### **Walker Reserve, MS-19-004**

Please accept the following comments from El Paso County Public Health regarding the 3-lot minor subdivision project referenced above:

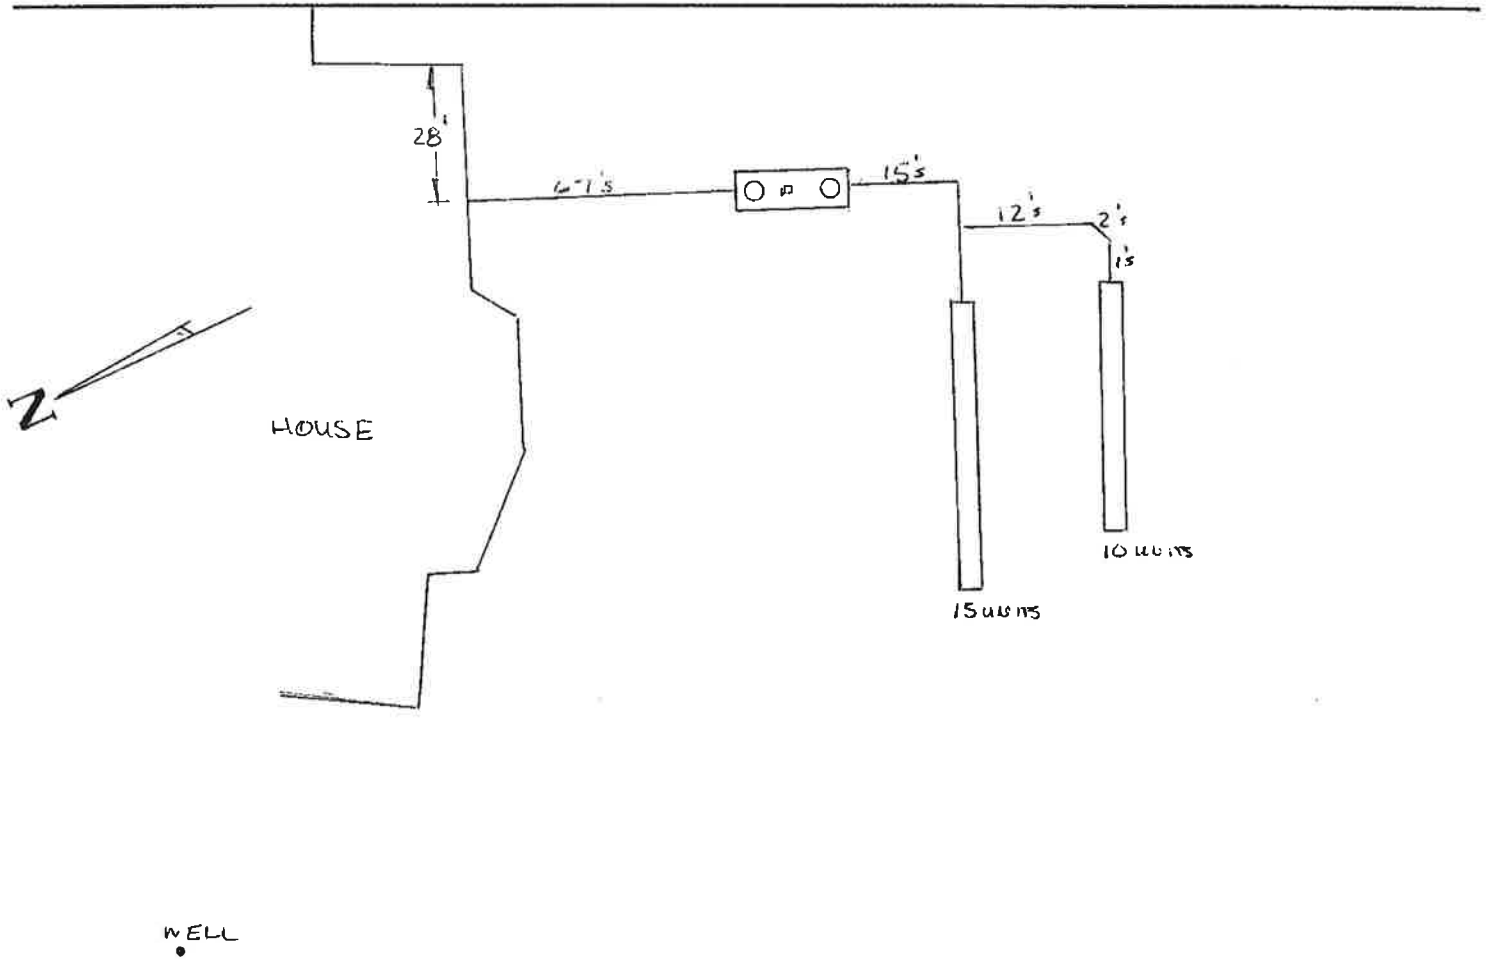
- All components of the 1994 OWTS must be on Lot 3 and meet the current OWTS Regulations minimum horizontal installation setbacks. Based on the 1994 drawing this does not appear to be an issue.
